M25 junction 28 improvement scheme

TR010029

9.28 Schedule of Changes to draft Development Consent Order

June 2021

**Fig 3.1 - HE Indicative alignment of amended Grove Farm egress (Change 8)**

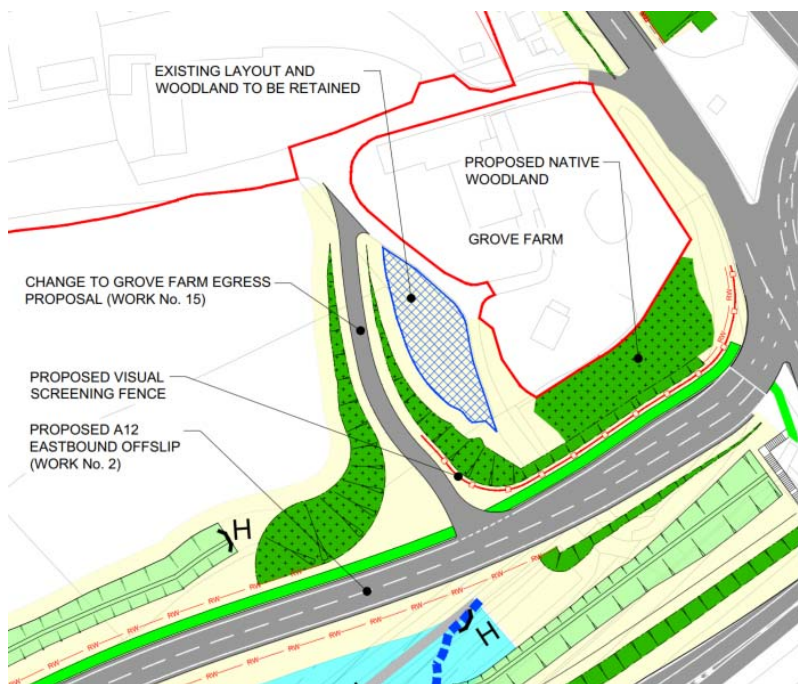
No	Provision	Suggested amendment	Explanation for change						
1.	Schedule 1	<p>Work No. 15 — Alterations to the existing egress from Grove Farm, approximately 50 87 metres in length, commencing at a point situated immediately to the north west of the existing Grove Farm residential property and terminating at Work No. 2, as shown on sheet 1 of the works plans.</p>	Amendment as a result of accepted change 8.						
2.	Schedule 2, Requirement 14	<p>(14)—(1) No part of the new loop road forming Work No. 6 is to be opened for traffic until a plan for the M25 Junction 28 roundabout containing details of the proposed operation of traffic signal timings or such other related measures as may be reasonably practicable to prevent any increase in delays for traffic on the A1023 Brook Street entering the M25 Junction 28 roundabout arising as a result of the authorised development has been submitted to and approved in writing by the Secretary of State, following consultation with the highway authorities within the Order limits.</p> <p>(2)The authorised development must be operated in accordance with the approved plan referred to in sub-paragraph (1) or such amended plan following consultation with the highway authorities within the Order limits.</p>	Correction. Wording agreed with TfL.						
3.	Schedule 6	<table border="1"> <thead> <tr> <th data-bbox="528 1114 911 1225"><i>(1)</i> <i>Plot Reference Number shown on Land Plans</i></th> <th data-bbox="911 1114 1290 1225"><i>(2)</i> <i>Purpose for which rights over land may be acquired</i></th> <th data-bbox="1290 1114 1668 1225"><i>(3)</i> <i>Relevant part of the authorised development</i></th> </tr> </thead> <tbody> <tr> <td data-bbox="528 1225 911 1372">1/25</td> <td data-bbox="911 1225 1290 1372">To install, access, monitor and maintain bird boxes.</td> <td data-bbox="1290 1225 1668 1372">Work Nos. 2, 6, 23B, 23D and 26 and other ancillary development (bird boxes and utilities)</td> </tr> </tbody> </table>	<i>(1)</i> <i>Plot Reference Number shown on Land Plans</i>	<i>(2)</i> <i>Purpose for which rights over land may be acquired</i>	<i>(3)</i> <i>Relevant part of the authorised development</i>	1/25	To install, access, monitor and maintain bird boxes.	Work Nos. 2, 6, 23B, 23D and 26 and other ancillary development (bird boxes and utilities)	Amendment as a result of accepted change 8.
<i>(1)</i> <i>Plot Reference Number shown on Land Plans</i>	<i>(2)</i> <i>Purpose for which rights over land may be acquired</i>	<i>(3)</i> <i>Relevant part of the authorised development</i>							
1/25	To install, access, monitor and maintain bird boxes.	Work Nos. 2, 6, 23B, 23D and 26 and other ancillary development (bird boxes and utilities)

4.	Schedule 8	<table border="1"> <thead> <tr> <th data-bbox="528 563 909 675"><i>(1)</i> <i>Plot Reference Number shown on Land Plans</i></th> <th data-bbox="909 563 1290 675"><i>(2)</i> <i>Purpose for which temporary possession may be taken</i></th> <th data-bbox="1290 563 1666 675"><i>(3)</i> <i>Relevant part of the authorised development</i></th> </tr> </thead> <tbody> <tr> <td data-bbox="528 675 909 794">1/21a</td> <td data-bbox="909 675 1290 794">Construction works relating to the realignment of stretches of Weald Brook.</td> <td data-bbox="1290 675 1666 794">Work Nos. 23A and 23B</td> </tr> <tr> <td data-bbox="528 794 909 914">1/26</td> <td data-bbox="909 794 1290 914">Construction working area for alterations to the existing egress from Grove Farm.</td> <td data-bbox="1290 794 1666 914">Work No. 15</td> </tr> <tr> <td data-bbox="528 914 909 1034">1/28a</td> <td data-bbox="909 914 1290 1034">Construction working area for alterations to the existing egress from Grove Farm.</td> <td data-bbox="1290 914 1666 1034">Work No. 15</td> </tr> </tbody> </table>			<i>(1)</i> <i>Plot Reference Number shown on Land Plans</i>	<i>(2)</i> <i>Purpose for which temporary possession may be taken</i>	<i>(3)</i> <i>Relevant part of the authorised development</i>	1/21a	Construction works relating to the realignment of stretches of Weald Brook.	Work Nos. 23A and 23B	1/26	Construction working area for alterations to the existing egress from Grove Farm.	Work No. 15	1/28a	Construction working area for alterations to the existing egress from Grove Farm.	Work No. 15	Amendment as a result of accepted change 8.
